City of Portland, Maine - Building or Use Permit Application

Permit No: 05-0140	Issue Date:	CBL: 347 B028001
-----------------------	-------------	---------------------

RE: 142 Hennessy Dr – 347-B-028 – R3 Zone – application #05-0140

I am in receipt of your application to add a 6' x 32' farmer's porch to the front of your home at 142 Hennessy Dr. Your permit has been denied because you are not meeting the requirements of the Land Use Zoning Ordinance.

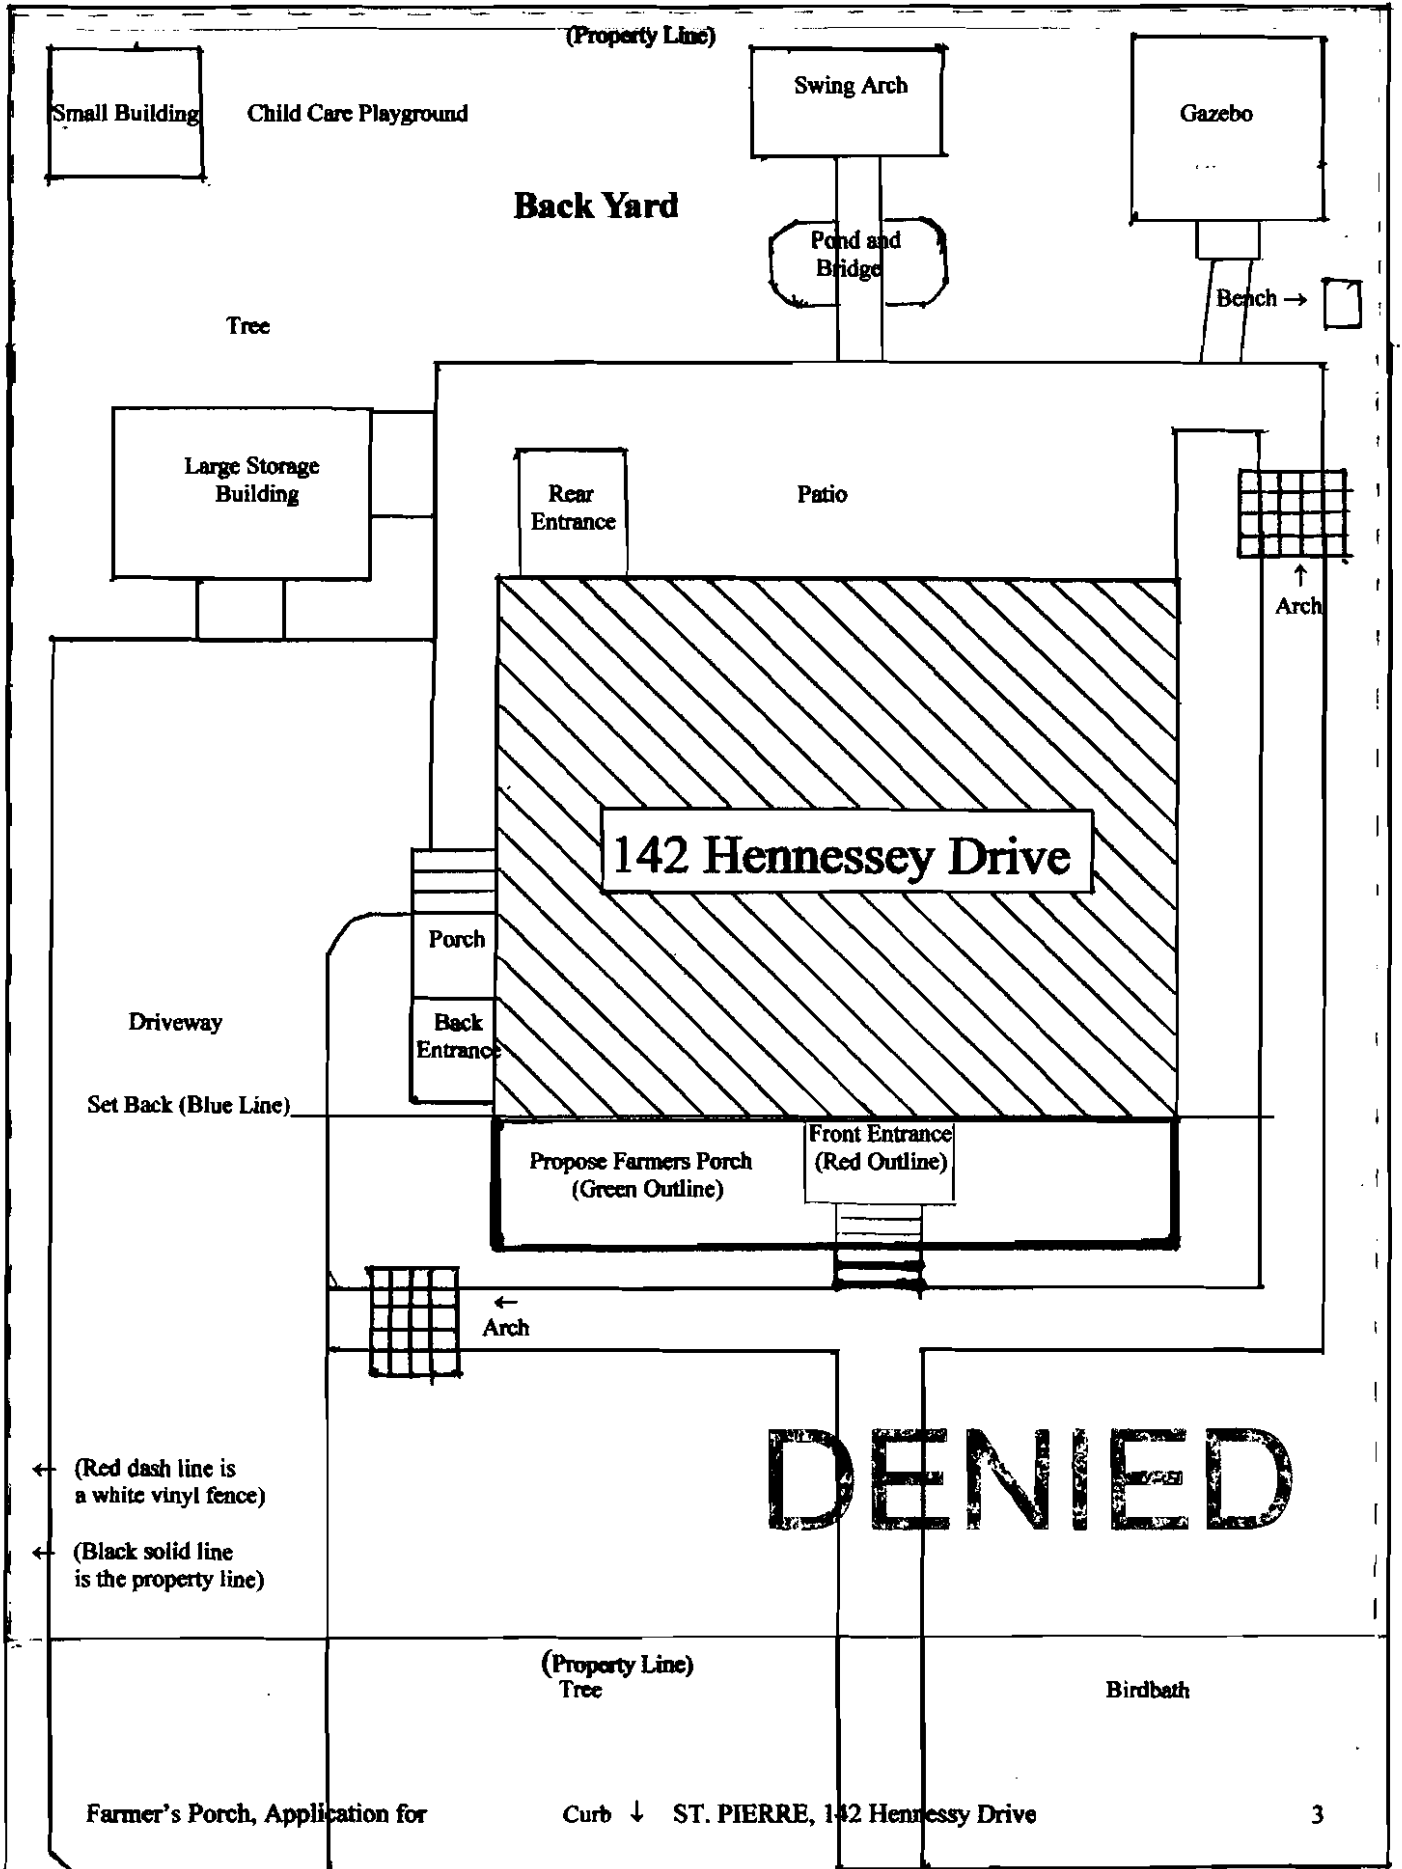
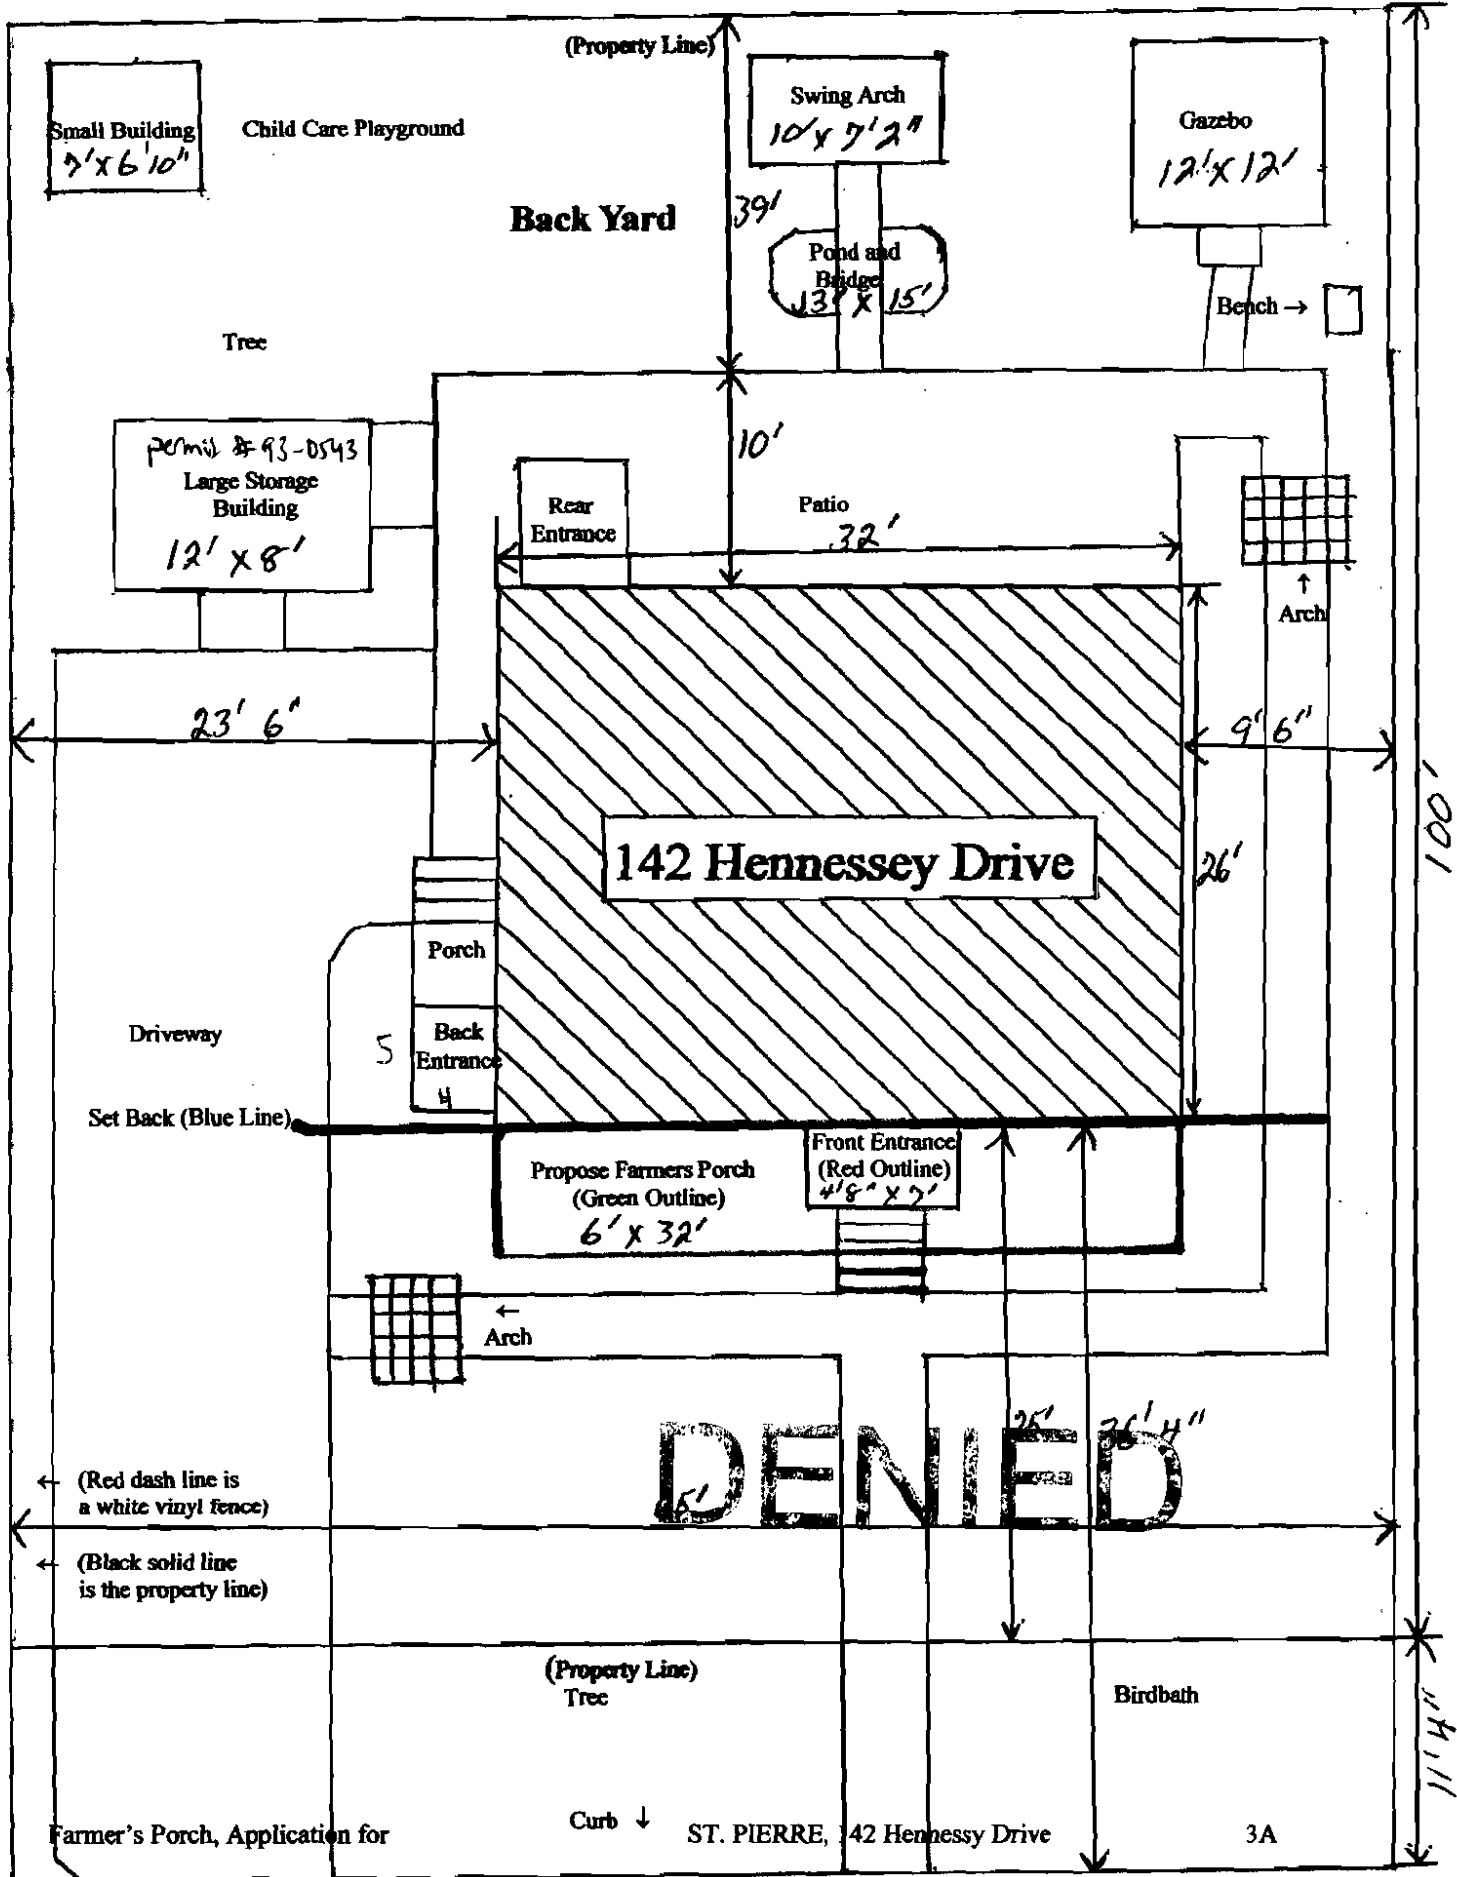
Note: 2/14/05 Spoke w/Susan St. P. To verify the property pins in front and the distance. The house is currently 25' from the front line. Only 50 sf is allowed into the setback. This permit is denied as submitted, if they want to re-build the existing porch new submissions will be needed. I gave my # to call with further questions before I formally deny it. **Ok to Issue:**

Section 14-90(d) 1 of the R3 Residential Zone requires a front setback to be a minimum of 25'. The submitted plot plan shows 18'. There are no exceptions to this zoning requirement; therefore, I cannot allow the construction of these decks.
